**FINAL DRAINAGE REPORT  
FOR  
STERLING RANCH RECYCLING FACILITY**

**February 2024  
Project No. 25188.14  
PCD Filing No: PPR2341 & SF2325**

This document is the Final Drainage Report for Sterling Ranch Recycling Facility. The purpose of this report is to identify on-site and off-site drainage patterns, areas tributary to the site, and compare existing and proposed drainage conditions.

STERLING RANCH RECYCLING FACILITY PROPOSED DRAINAGE MAP

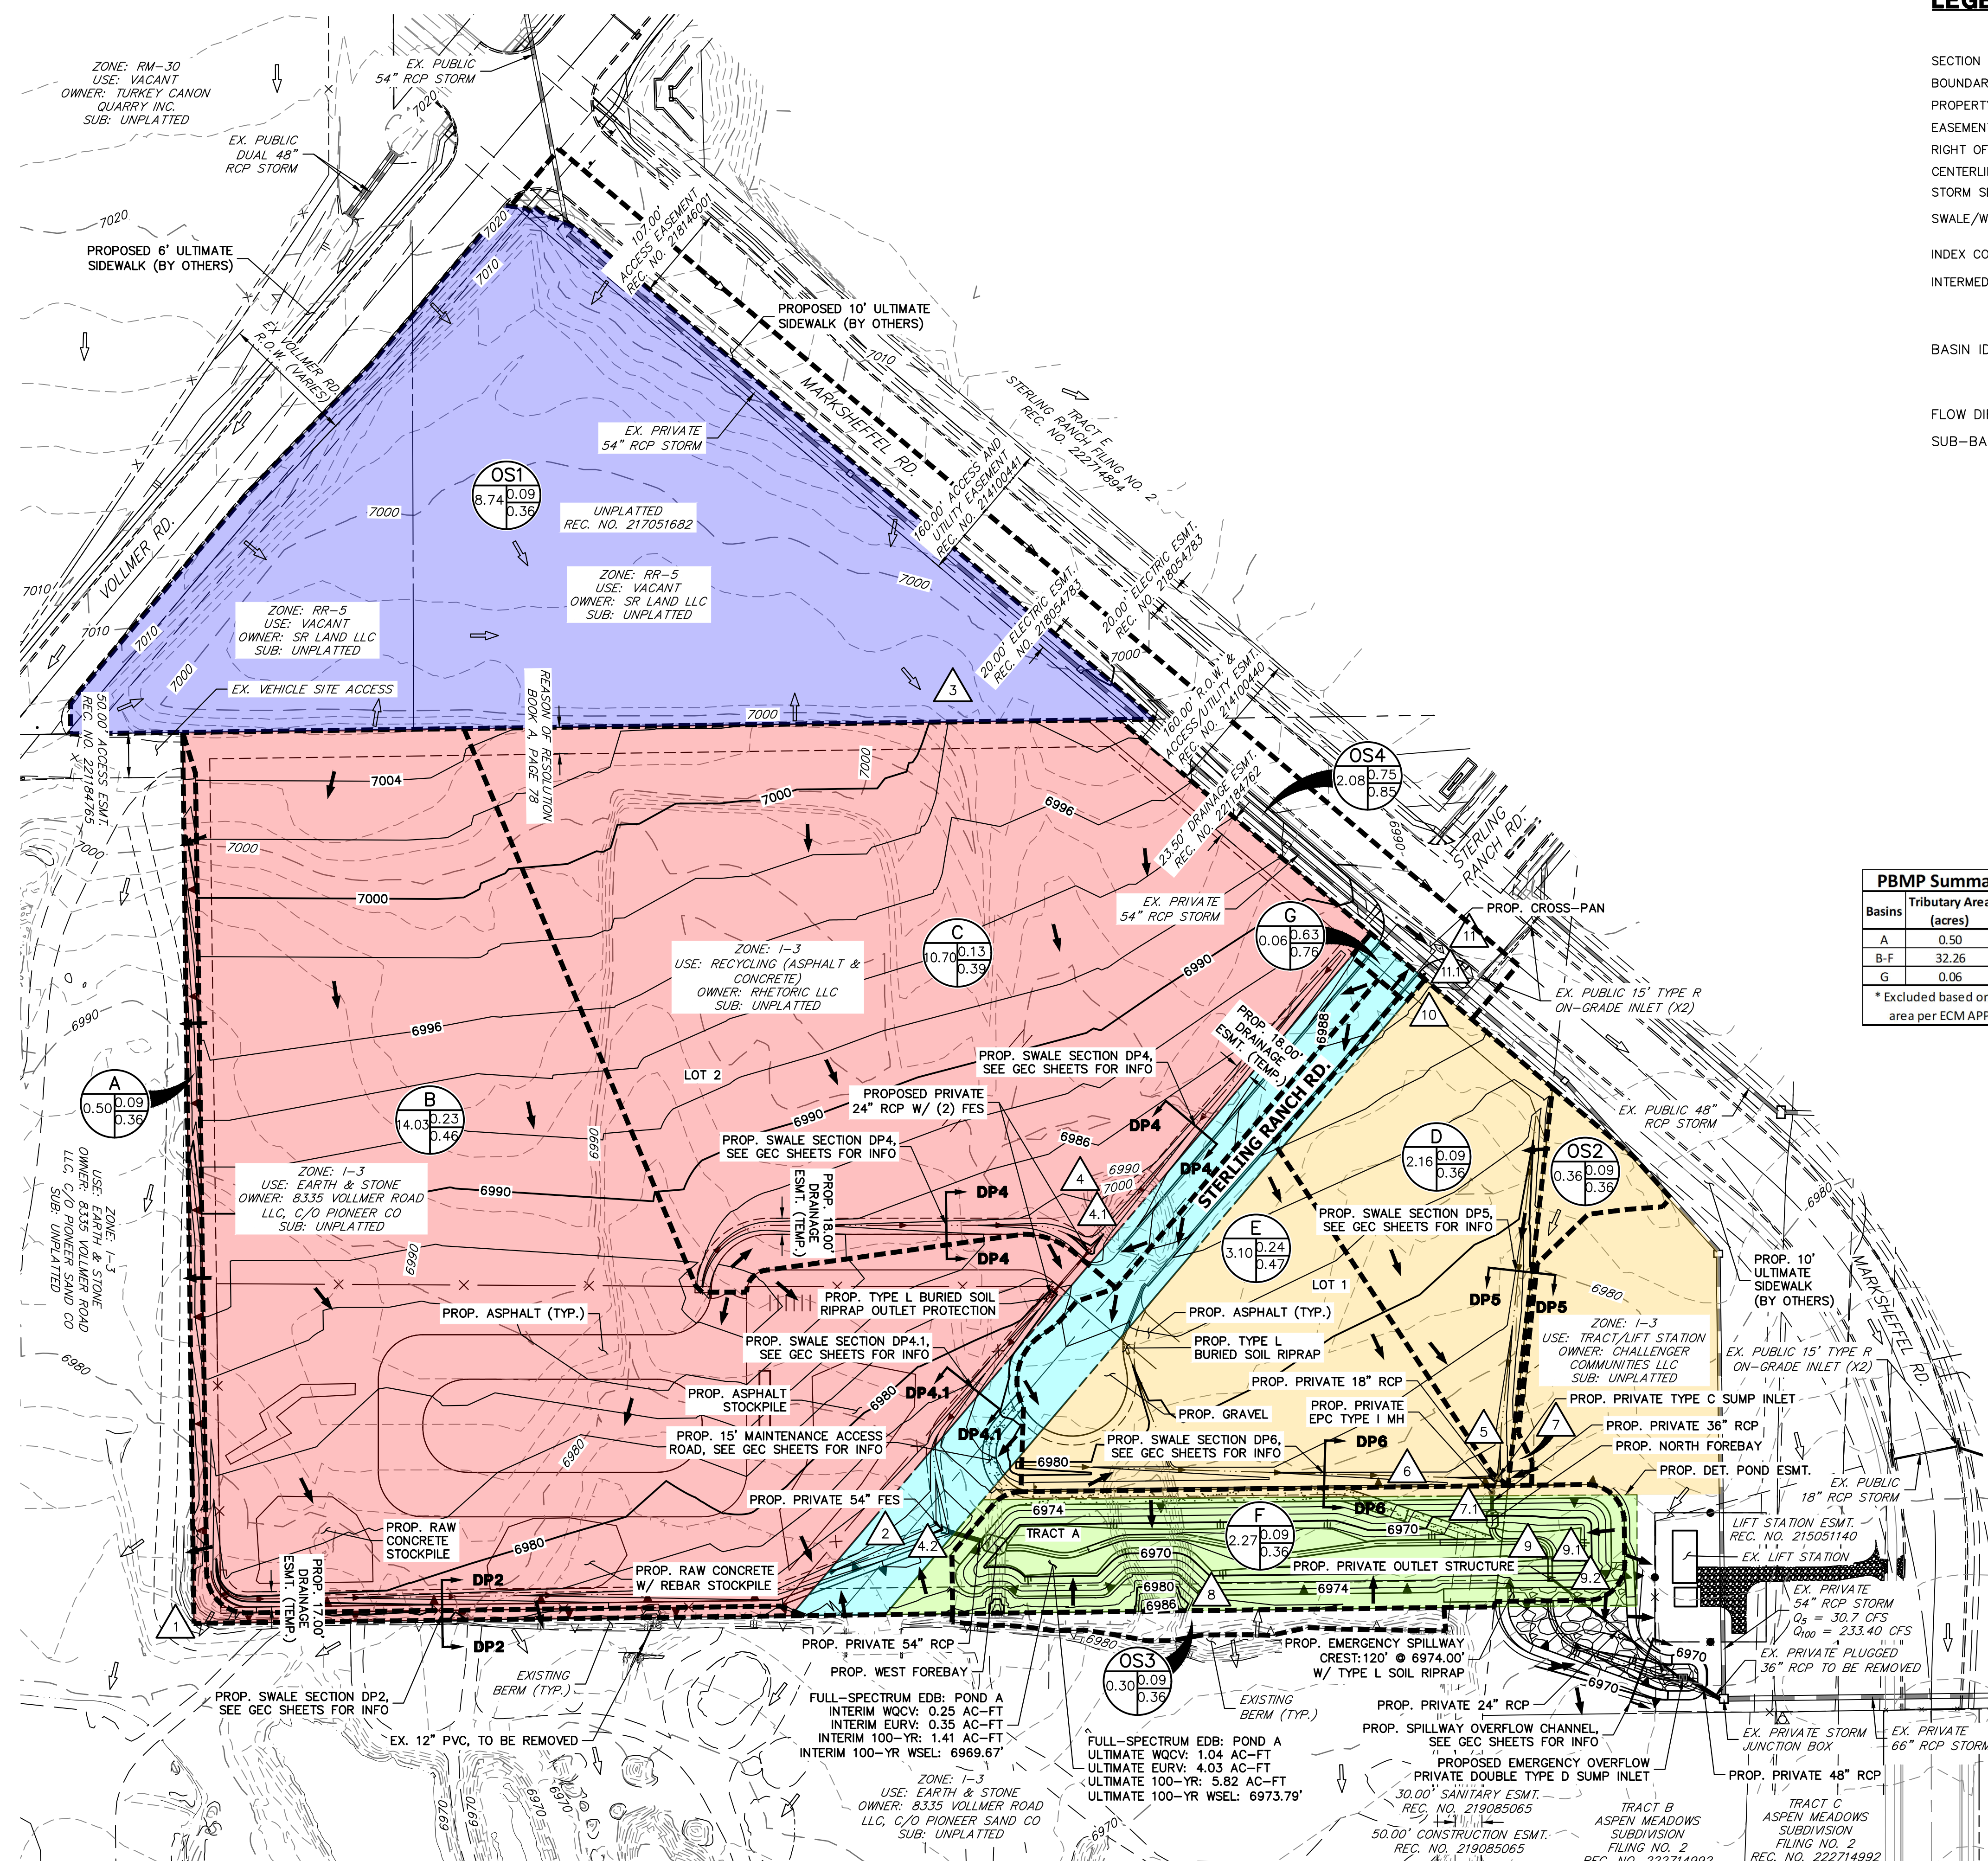
Explain why this basin is considered "off-site" when it is shown within the LOD on the GEC Plans for this project. And address WQ treatment/exclusion for it. Is runoff from it to be treated via a previous or future project for the road?
